Our Case Number: ACP-323535-25

Re: Galway County Council (N63 Abbeyknockmoy Village Active Travel) Compulsory Purchase Order
No.4 2025
In the townlands of Cullagh South and Cullagh North, Abbeyknockmoy, County Galway

RE: PATRICK O'DONOHUE AND EIMEAR LOUGHNANE O'DONOHUE
ABBEYKNOCKMOY, TUAM, COUNTY GALWAY
GALWAY COUNTY COUNCIL COMPULSORY PURCHASE ORDER (No. 4) 2025
- N63 ABBEYKNOCKMOY VILLAGE ACTIVE TRAVEL, COUNTY GALWAY
PLOT REFERENCE NO. 104.01 AND 104.02
AN COIMISIÚN PLEANÁLA REFERENCE: CH07.323535

Project Name: LA12/23 Part 8 Application for Active
Travel scheme in Abbeyknockmoy Village

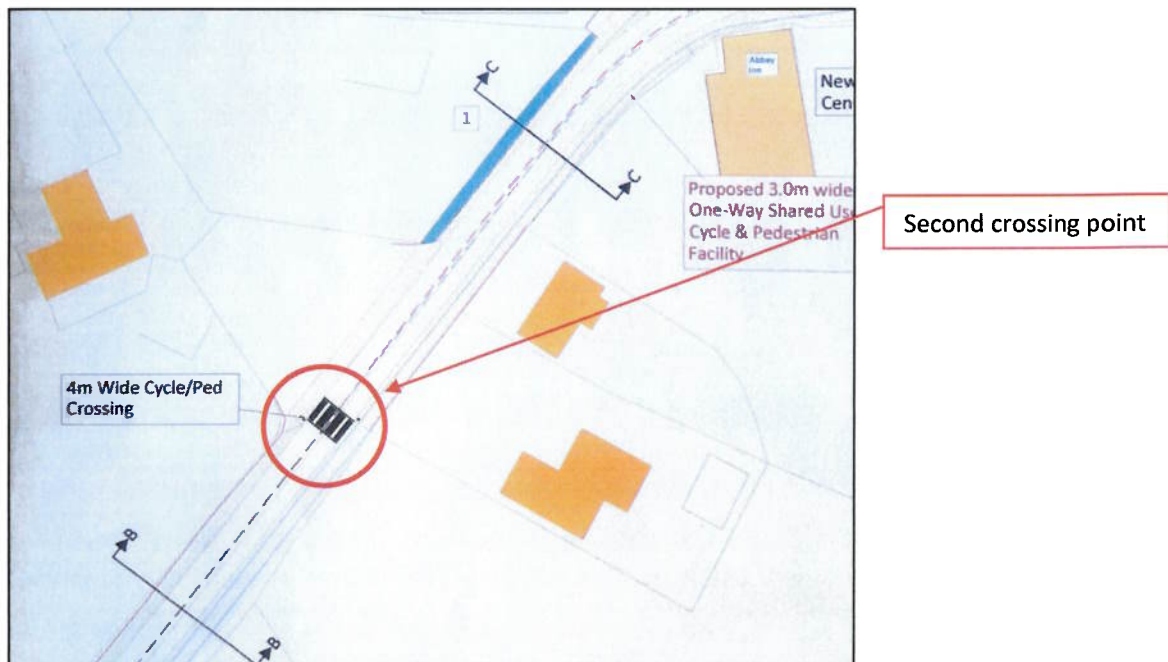
Our clients consider that a second pedestrian crossing point should be provided at the western side of the village. The proposed development is being designed in accordance with the Design Manual for Urban Roads and Streets (DMURS). DMURS acknowledges that pedestrians will follow the desire line (i.e. take the shortest route), even if this conflicts with the location of formal crossings and pedestrian control measures. DMURS also identifies that well designed and frequently provided crossings are critical to the balancing of movement priorities, the design of crossings, and the frequency at which they are provided, will have a significant impact on pedestrian/cyclist mobility and comfort and the flow of vehicular traffic and that the location and frequency of crossings should align with key desire lines and be provided at regular intervals.

The provision of a second raised pedestrian crossing on the western approach to the village would align with the principals of DMURS and would greatly assist in the reduction of speed of vehicles approaching the village from the west. This would provide a similar level of provision in other recently completed active travel measures in local villages, such as Barnaderg where the introduction of a raised pedestrian crossing on both sides of the village core has greatly reduced traffic speeds.

The need for a second crossing was clearly identified by the local authority and was included in the earlier draft design proposal for the scheme. Our clients feel that it is incumbent on the local authority to include a second pedestrian crossing on the western side of the village. This would encourage a reduction in traffic speeds on this section of roadway and give some piece of mind to current residents, pedestrians, and cyclists.

Extract from drawings No. P8-N63AT-LP-03

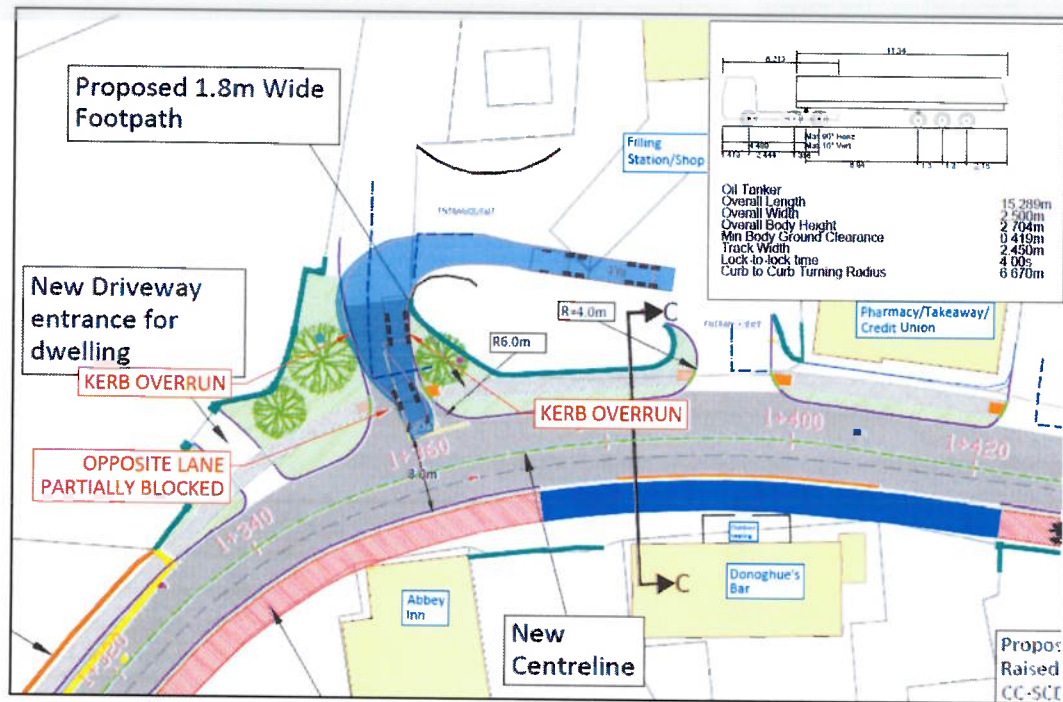
As an example of the deficiency in the design proposal swept path analysis for an oil tanker entering and exiting the site via the L2128 junction are outlined below. They clearly indicate that it will not be possible for an oil tanker to access and leave the petrol filling station without overrunning the kerbs in a number of locations and completely crossing over the oncoming traffic lane on the L2128 roadway. It is not possible for the tanker to manoeuvre into position at the stop line without partially blocking the opposite lane. This will cause a traffic obstruction and have the potential to cause collisions.

It will not be possible for a fuel or other delivery trucks to safely access the petrol filling station/shop if the proposed alterations are carried out as planned. The proposed alterations to the L2128 junction taken together with the loss of parking spaces to the front of our client's dwelling house and across the frontage of the petrol filling station will significantly reduce the access to our client's business for HGV drivers.

We would ask that the proposal is given proper consideration in this regard and that all vehicle types which currently access the site, or could reasonably be expected to access the site, are considered and accommodated in order to minimise the negative impacts on our client's business.

Existing delivery area for public house

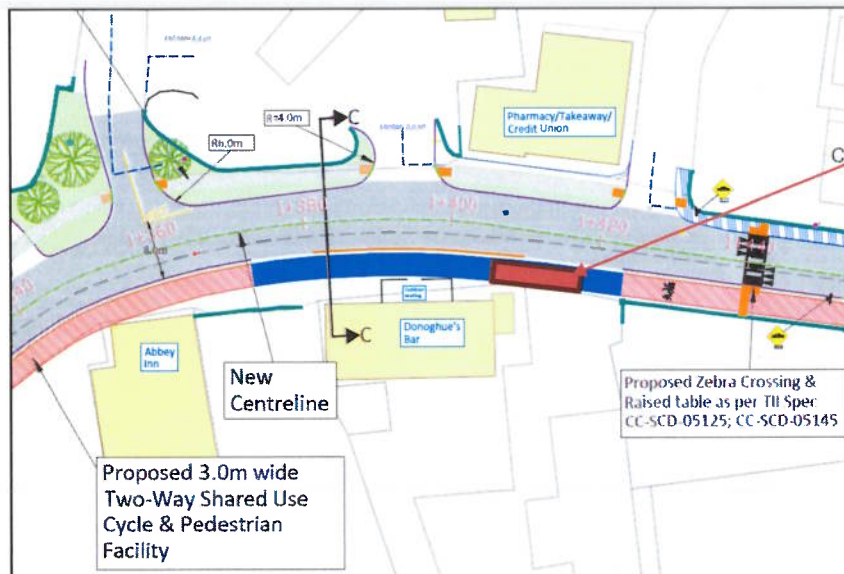
The proposed design will result in the loss of the existing parking and delivery area to the front of O'Donohoe's public house. This area has been used as a delivery area to accommodate articulated truck deliveries for four generations. The proposed double kerb arrangement between the road edge and shared surface will make it impossible for an articulated delivery truck to safely park and offload deliveries. It does not appear that the loss of this delivery area or how deliveries can take place to the public house has been considered in the design.

We would ask that this element of the proposal is redesigned to accommodate access for deliveries to the public house.

Parking spaces adjacent to public house & dwelling. Extract from draft proposal.

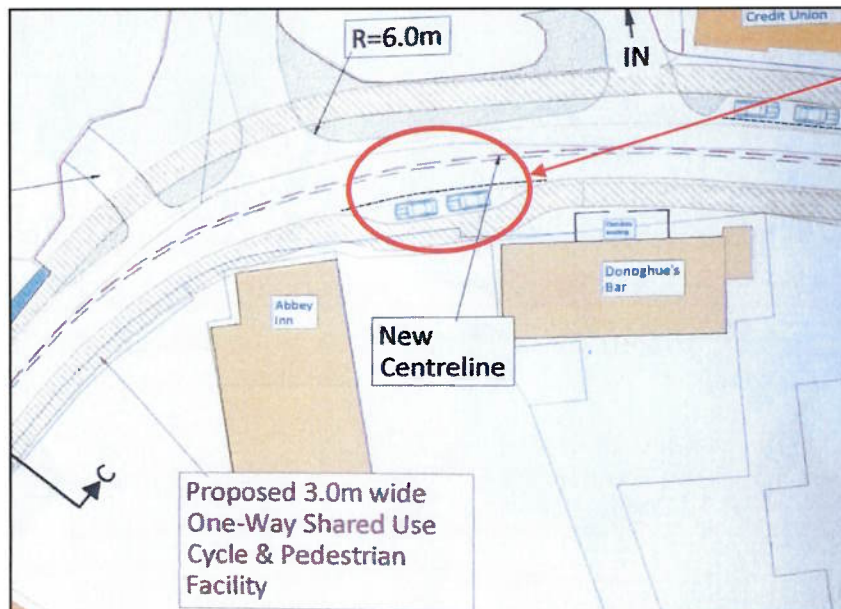
We note that the proposed design will result in the loss of the existing parking spaces to the front of the residence located above O'Donohoe's public house. It is considered that the design of the shared surface across the front of the public house and residence may unduly restrict access to the dwelling house and impact on the existing long established parking spaces serving the residence. The need for parking spaces in this location was identified and included in the draft plan.

We do not feel that this has been afforded sufficient consideration in the proposal.
